**RE: DRB Justification Letter for submittal for Final Sign-Off for EPC Approved Site Development Plan for Building Permit – Project Number 1006973**

Joshua J. Skarsgard (“**Agent**”) acted as agent on behalf of Century Bank for EPC application 16EPC-40006 for approval of a Site Development Plan for Building Permit Amendment. The Subject Property has since been sold to Red Shamrock 10, LLC, who is now the “**Applicant**” in this request for Final Sign-Off for EPC Approved Site Development Plan for Building Permit to the Development Review Board (“**DRB**”) on the real property described as:

The EPC issued a Notice of Decision on March 11, 2016 to approve Applicant’s application for a Site Development Plan for Building Permit Amendment. The Applicant attended the DRB hearing on April 20, 2016 for this application and was given additional comments from city agencies. The purpose of this Justification Letter is to provide responses as to how the Applicant has addressed those comments.

CONCEPTUAL GRADING & DRAINAGE PLAN

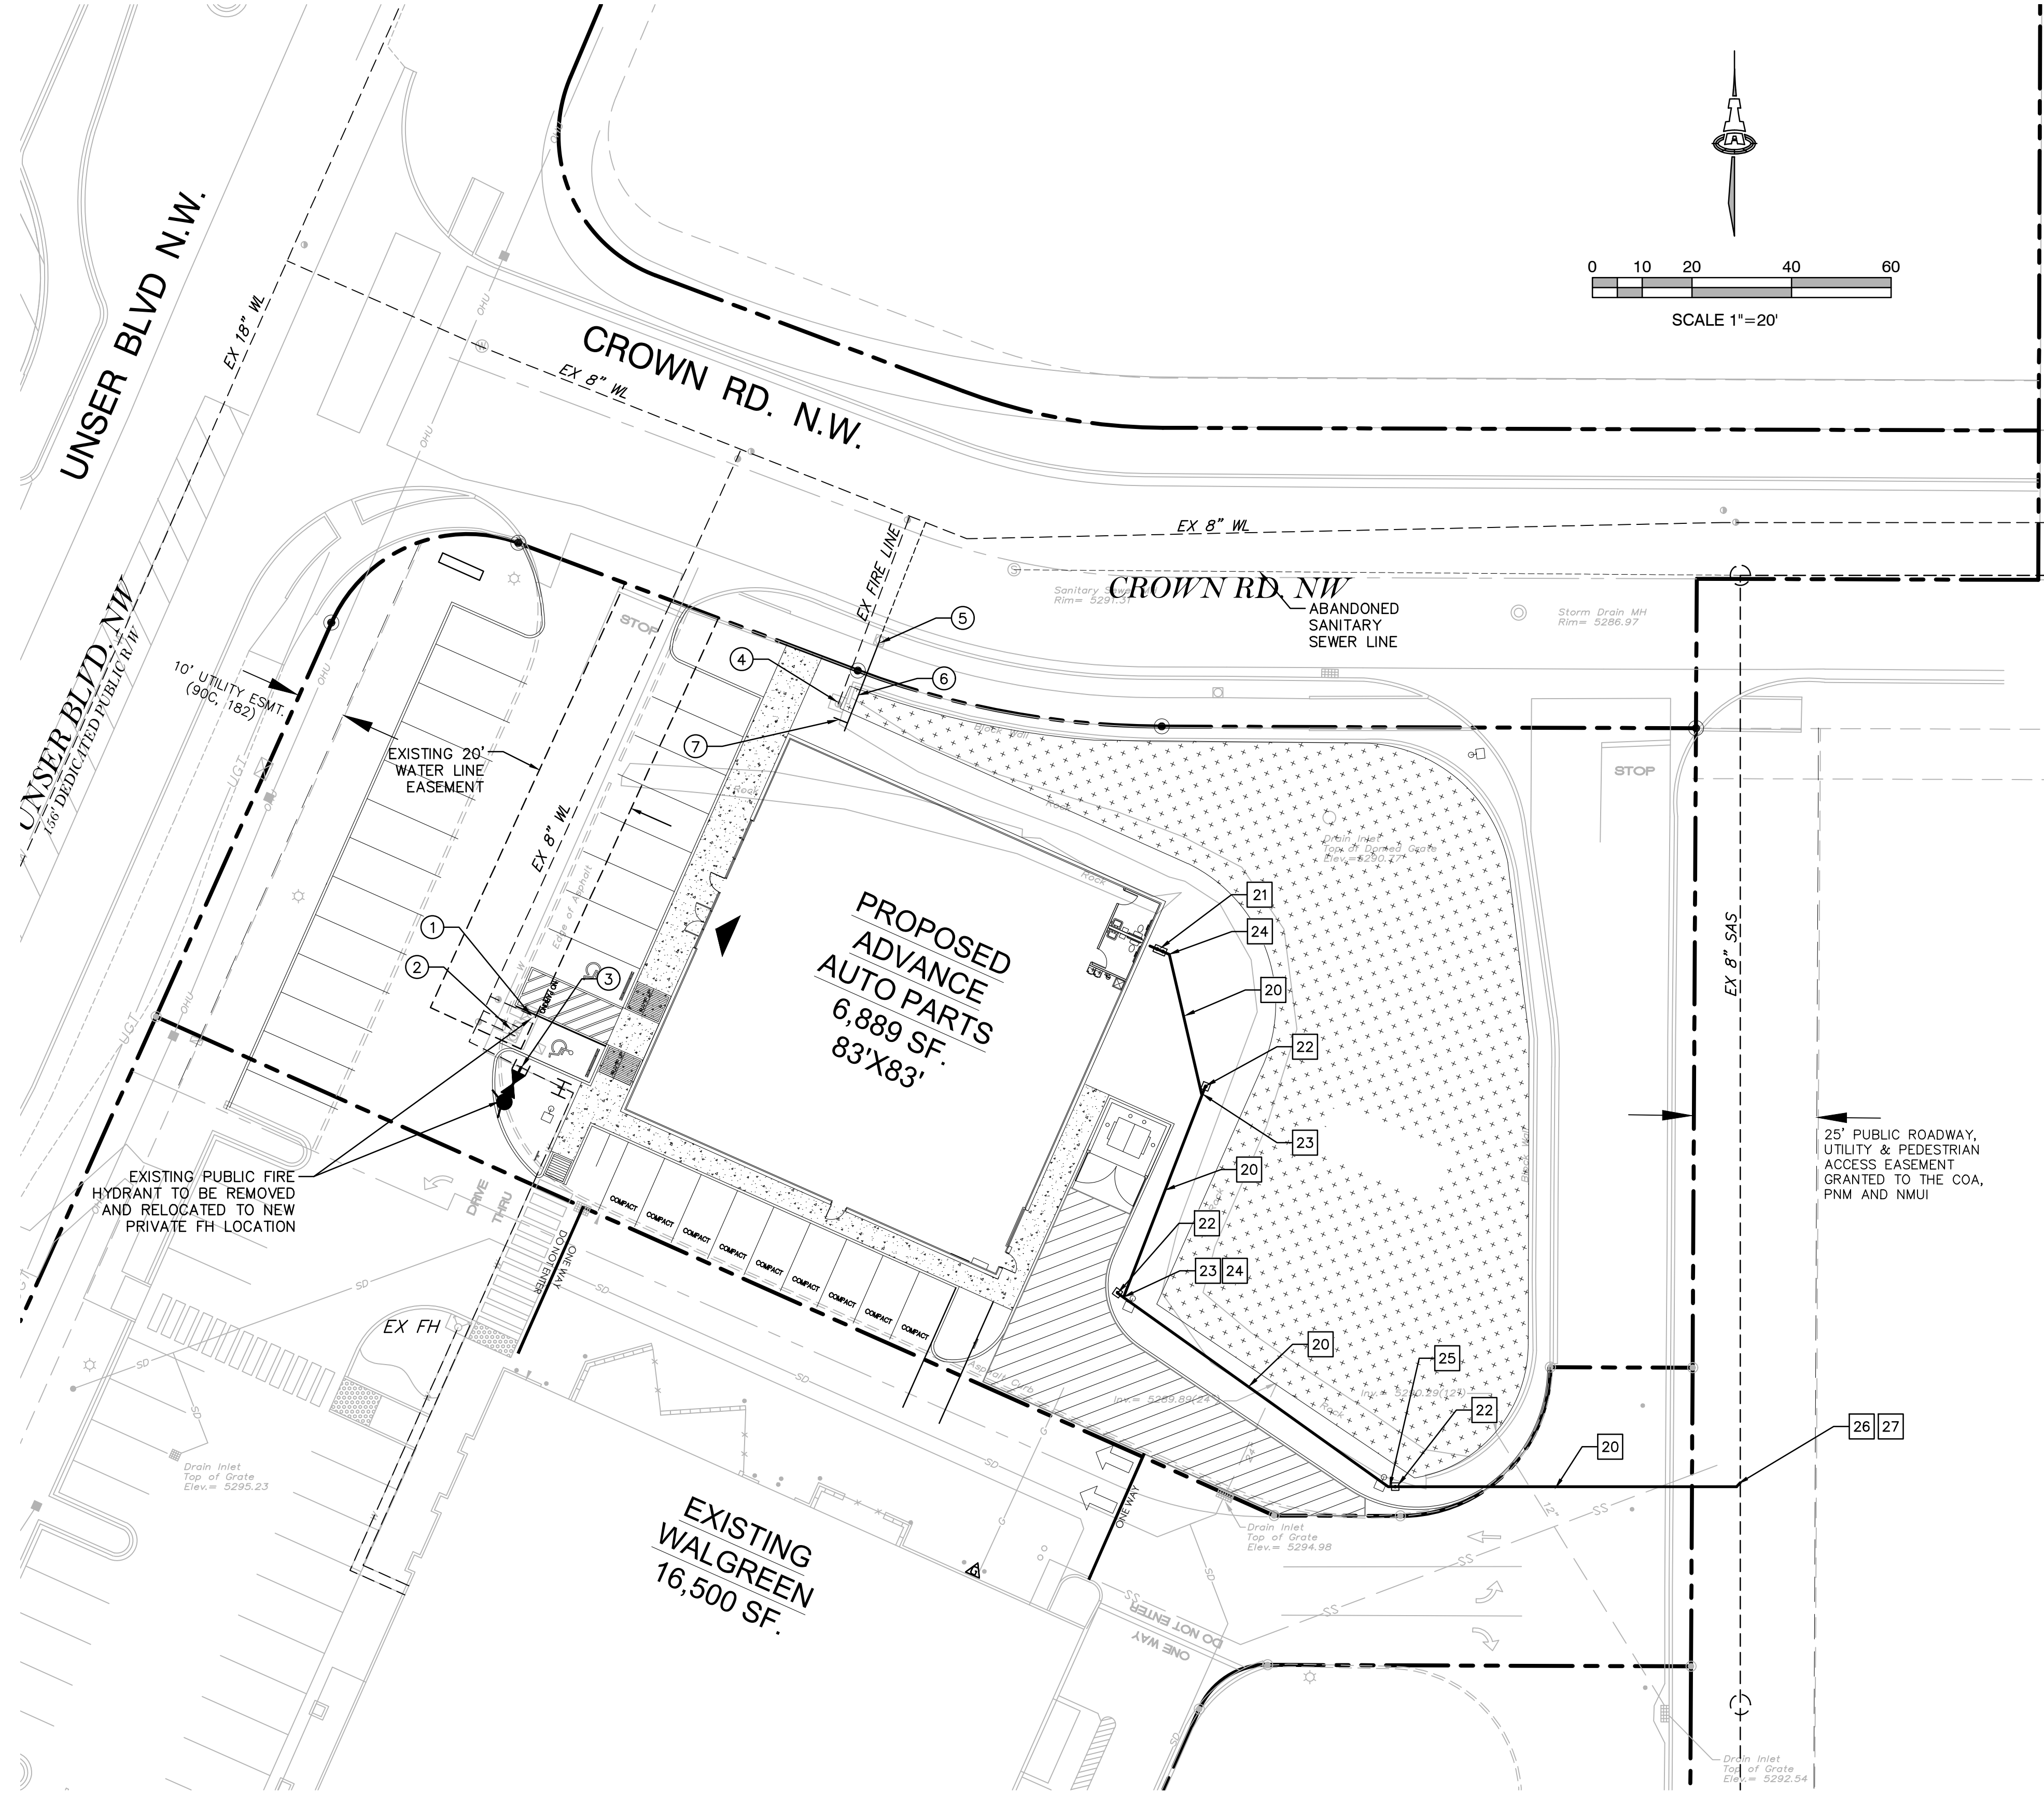
2. Drainage Report or Narrative should reference the original drainage plan for this site, A11D012.

*APPLICANT'S RESPONSE:* The Drainage Report does now reference the original grading drainage plan.

**C1**

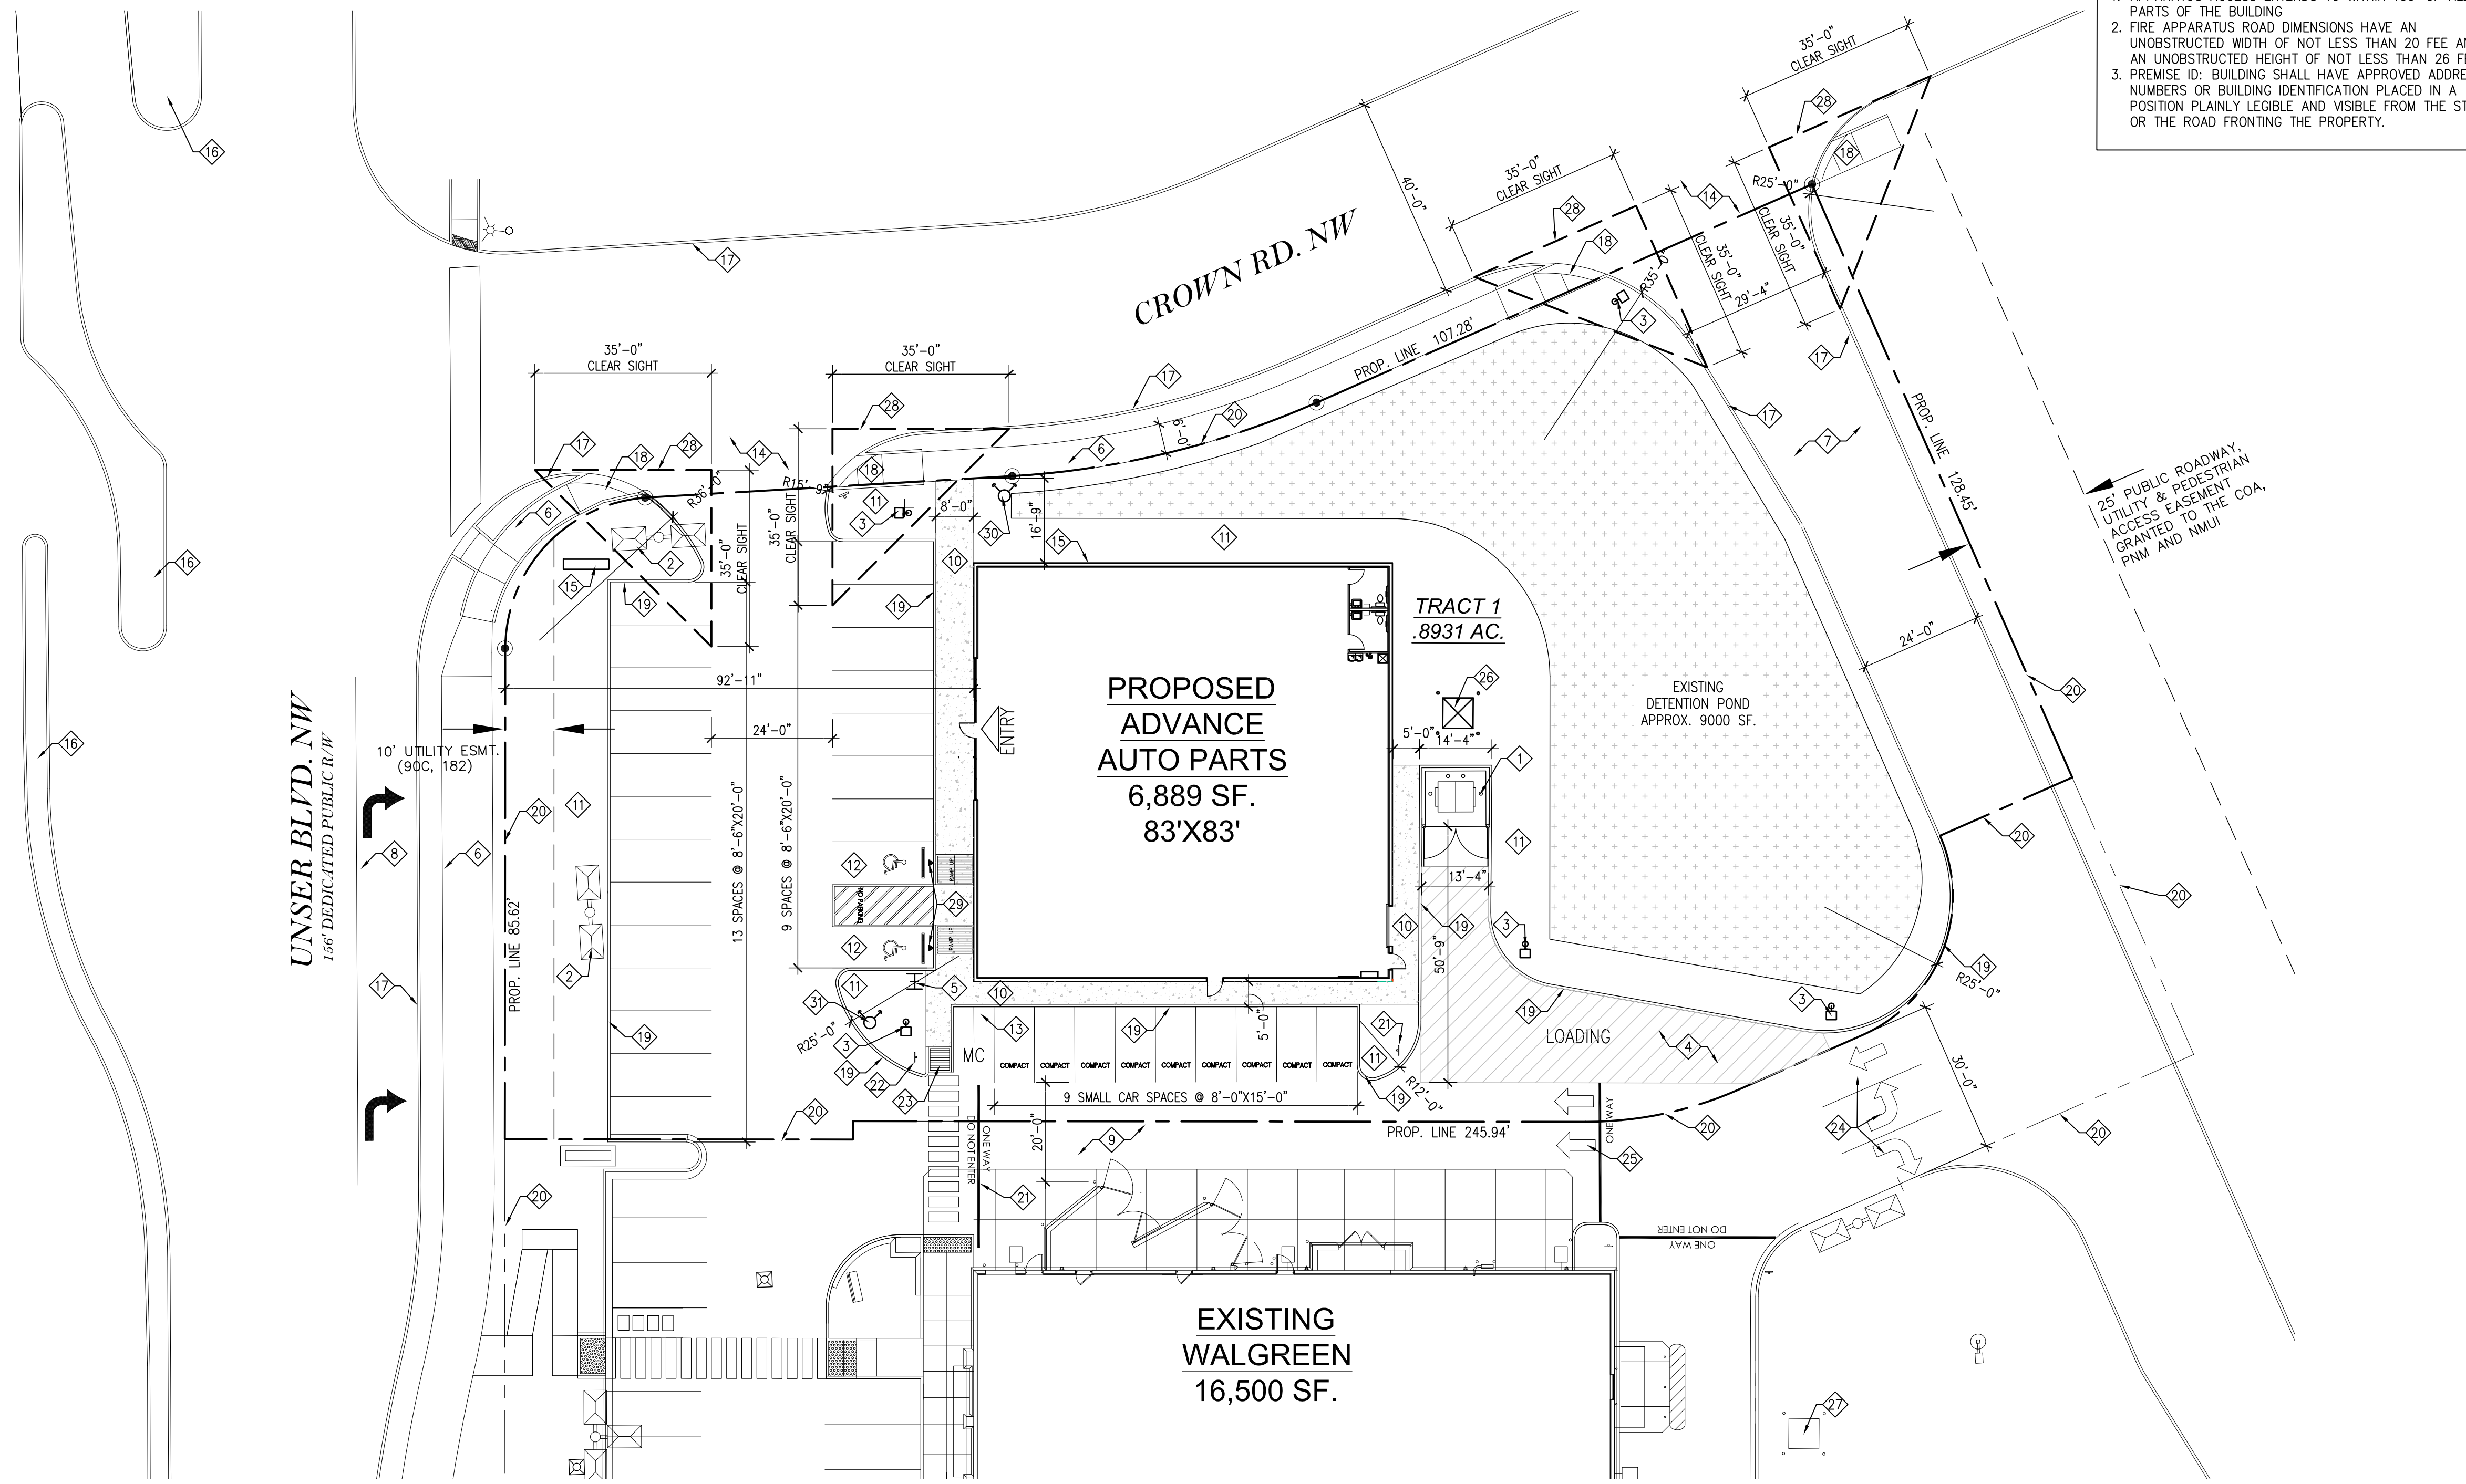
1. Add a “One-Way Do Not Enter” sign to the south of the access aisle south of the building.

3. Please add the clear sight triangle to each subdivision entrance. Add the following note as well: "Landscaping, fencing and signing will not interfere with clear sight requirements. Therefore, signs, walls, trees and shrubbery between 3 and 8 feet tall (as measured from the gutter pan) will not be acceptable in the clear sight triangle."

4. The ADA accessible parking sign must have the required language per 66-7-352.4C NMSA 1978 "**Violators Are Subject to a Fine and/or Towing.**" If that language is present it is not visible in the detail.

APPLICANT’S RESPONSE: A “One-Way Do Not Enter” sign and “One-Way Do Not Enter” pavement striping are located on the south side of the building as shown on the Site Plan as Key Notes 21 and 22.

*APPLICANT'S RESPONSE:* A clear sight triangle has been added to each subdivision entrance and Key Note 28 has been added.

*APPLICANT'S RESPONSE:* The ADA accessible parking sign shall have required language per 66-7-352.4C NMSA 1978 "**Violators Are Subject to a Fine and/or Towing**" as shown the Site Plan Key Note 29.
